CITY OF ALBUQUERQUE

**Re: Caliber's on Coors, Grading and Drainage Plan
Engineer's Stamp Date 12-18-13 (C13D025A)**

CALIBERS ALBUQUERQUE, NM GRADING AND DRAINAGE PLAN	DRAWN BY SBH DATE 12/18/13
		SHEET # C3 JOB # 2013033

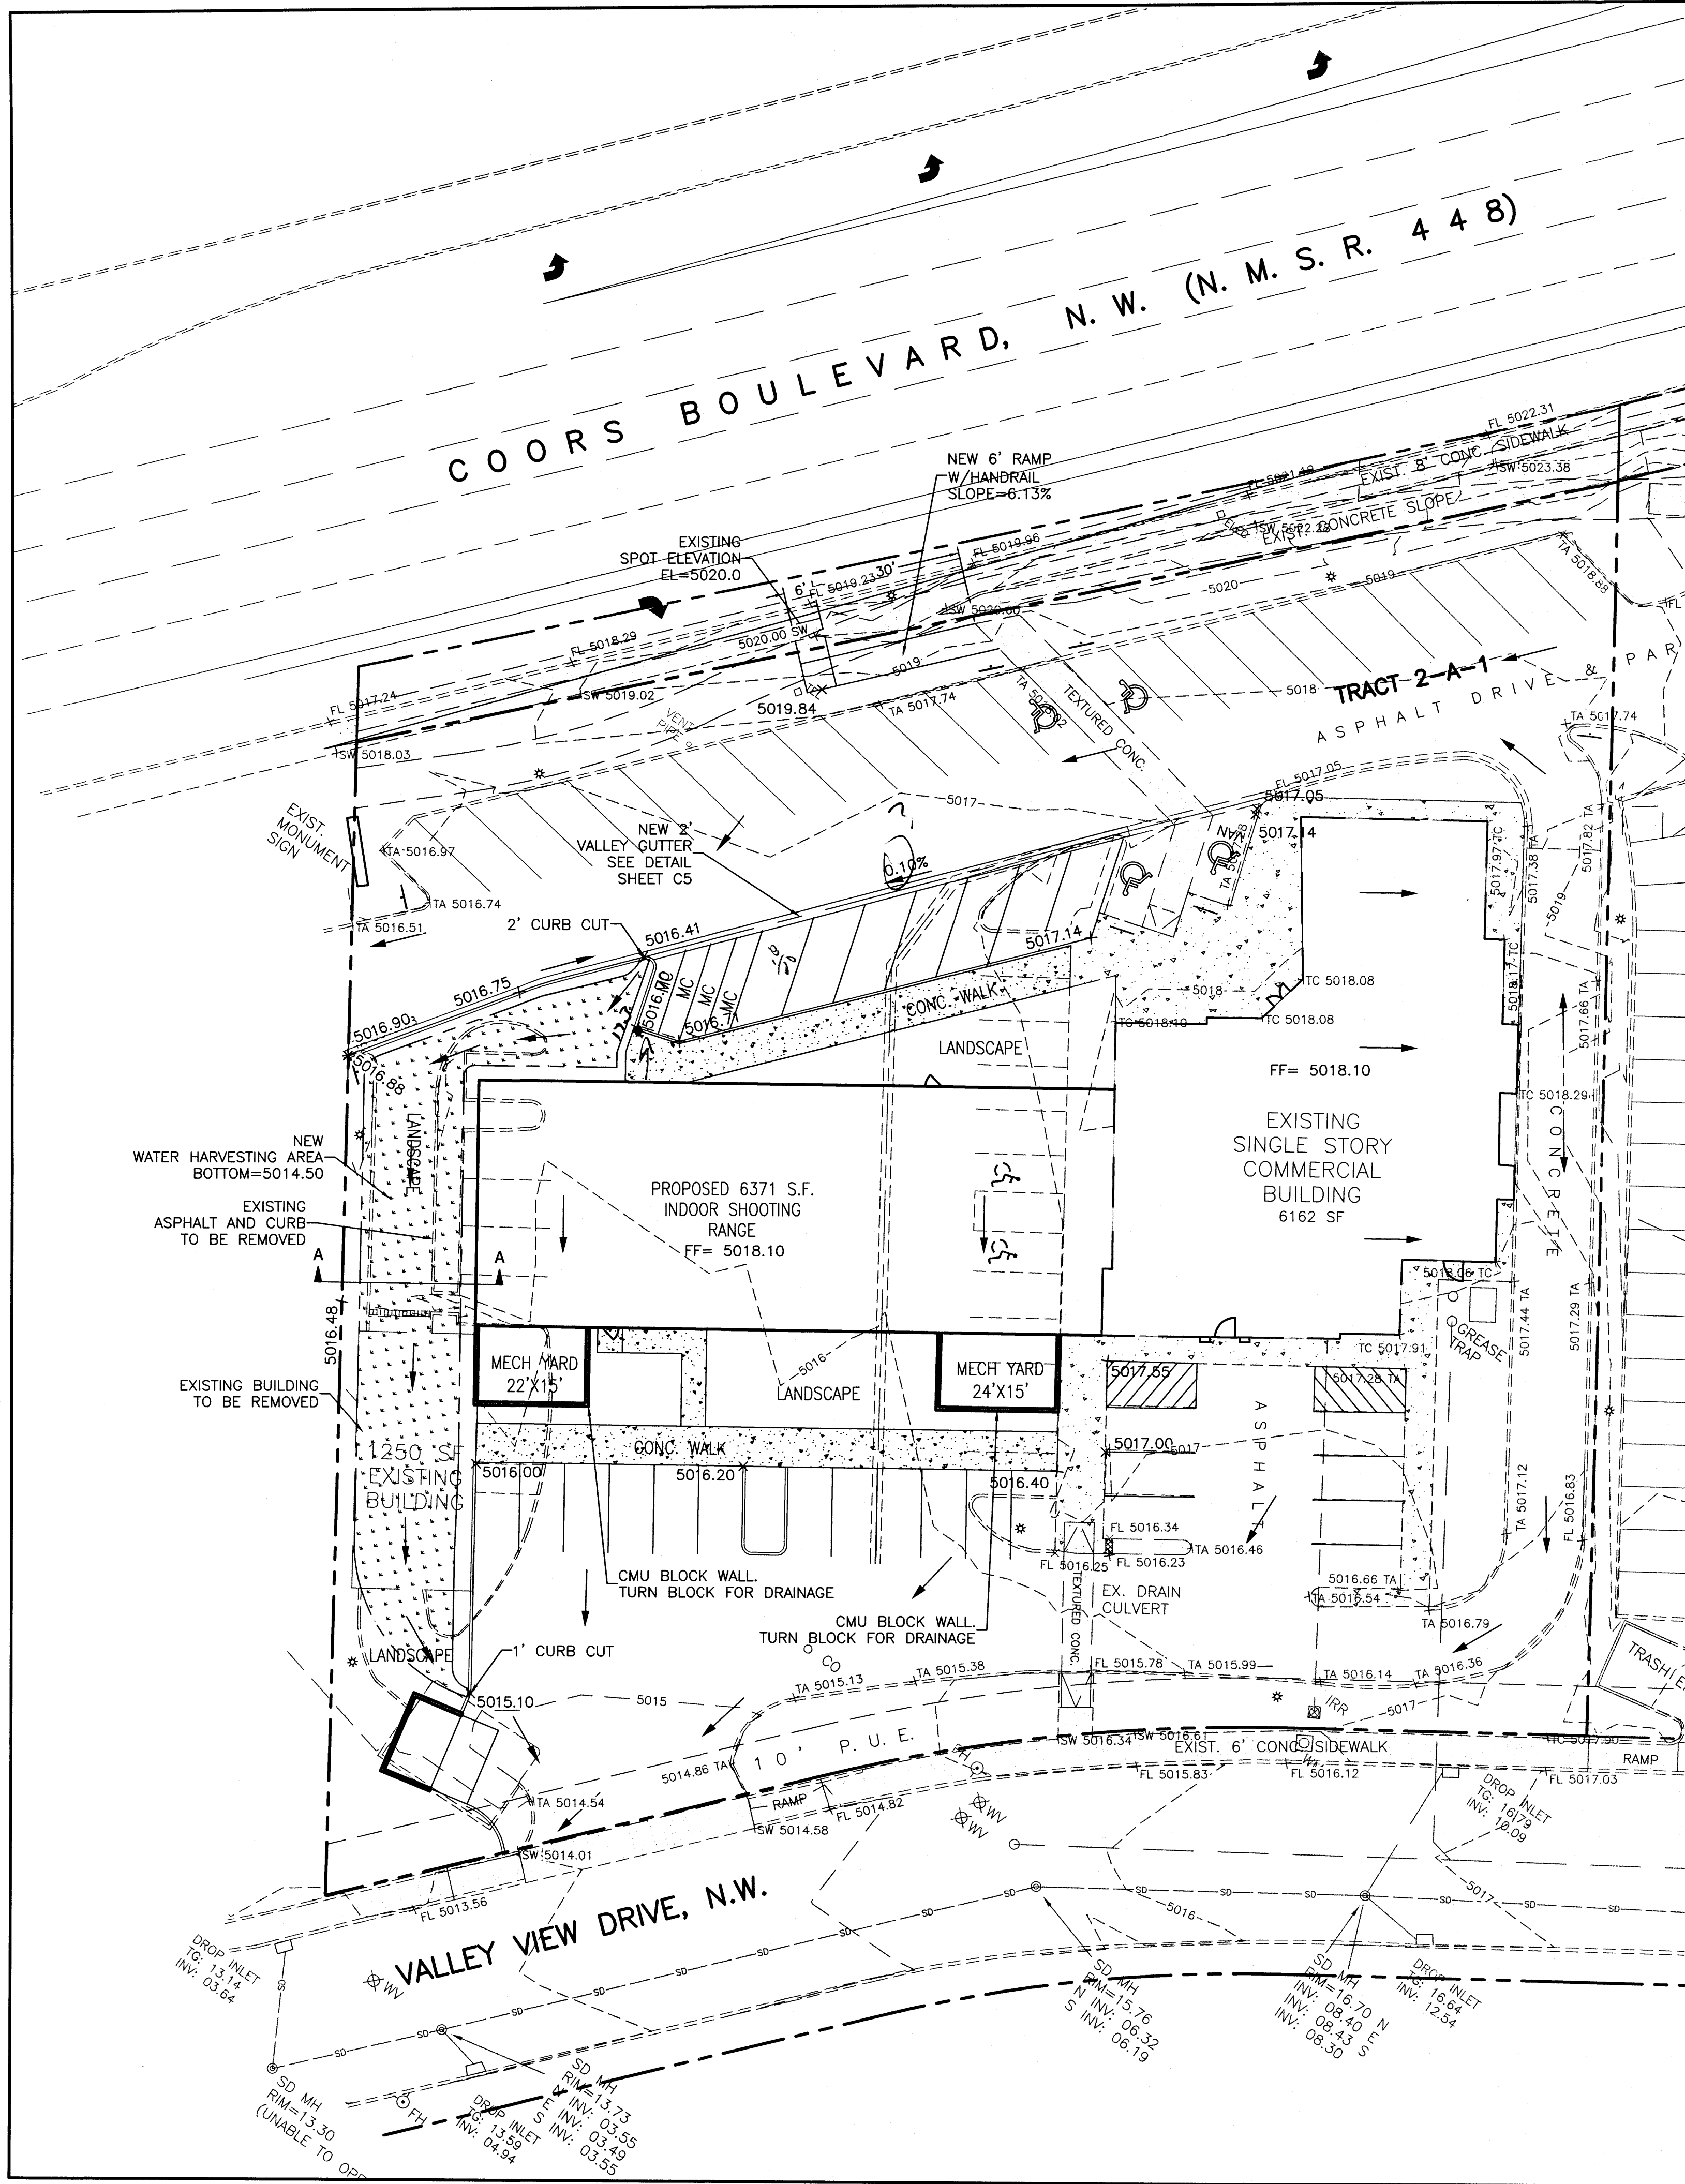
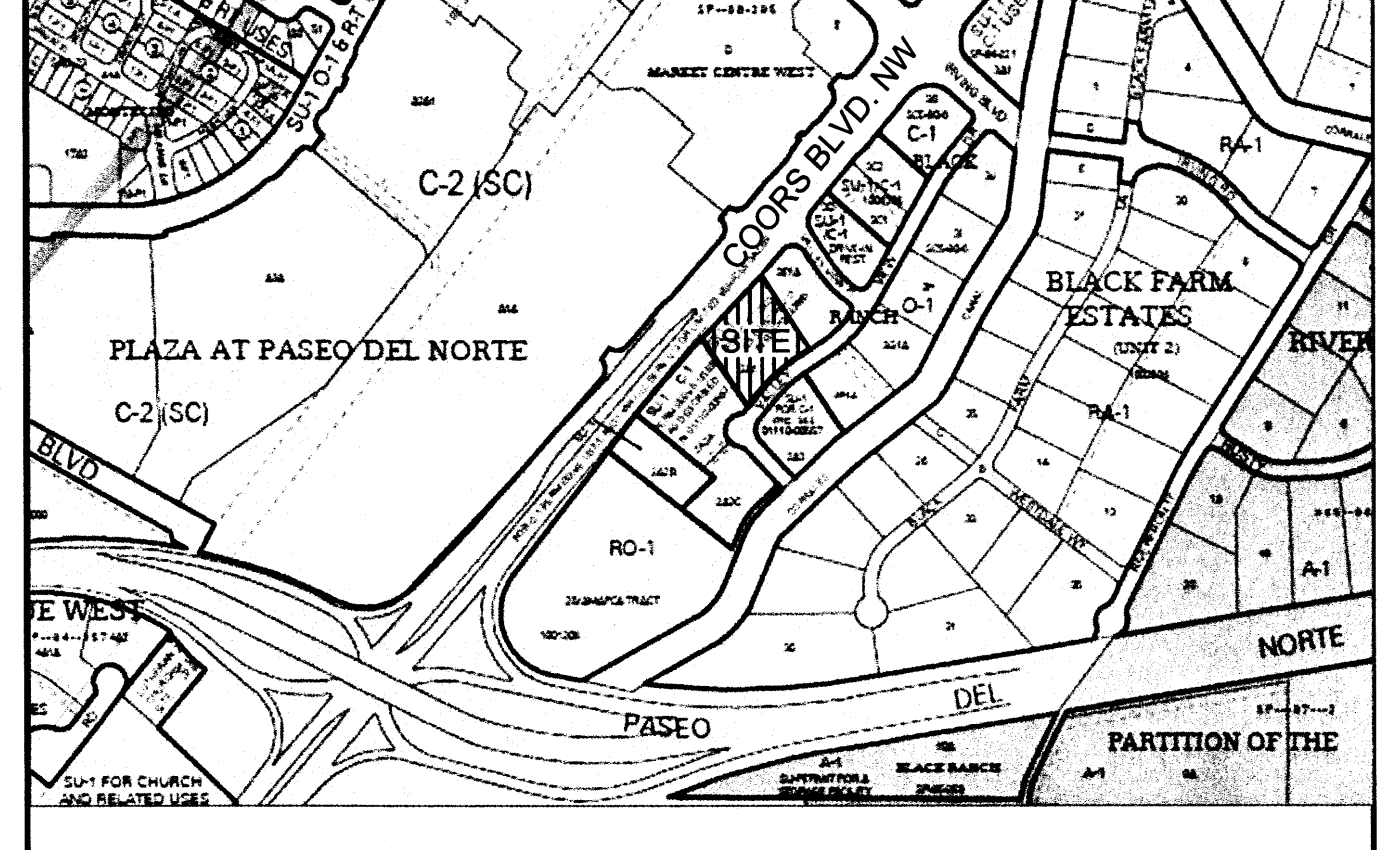
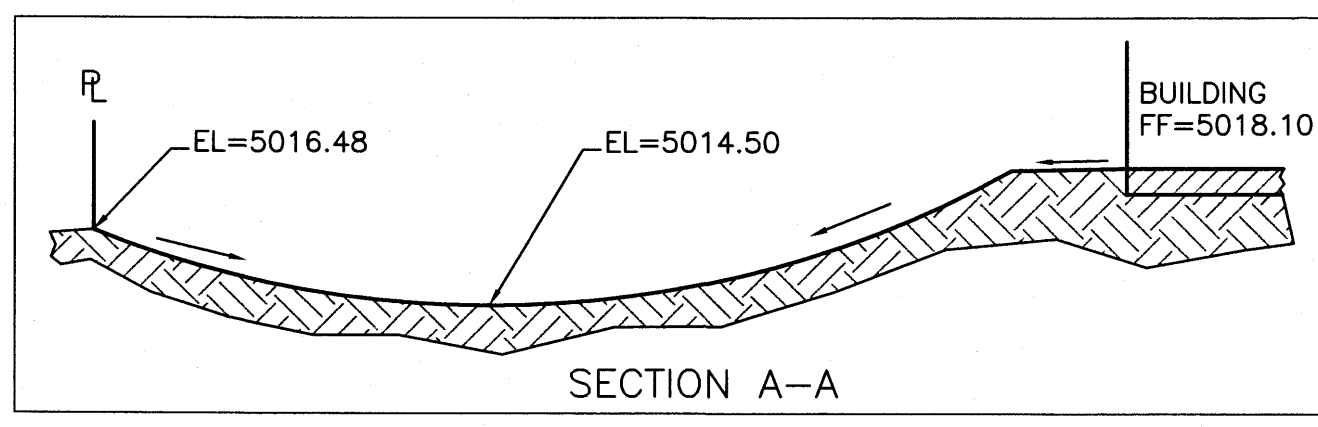
1. Consider increasing the parking lot slope from 0.1%.
2. Consider lowering the finished floor elevation as it appears difficult to achieve an acceptable ADA cross slope (8% proposed) on the sidewalk west of the building.
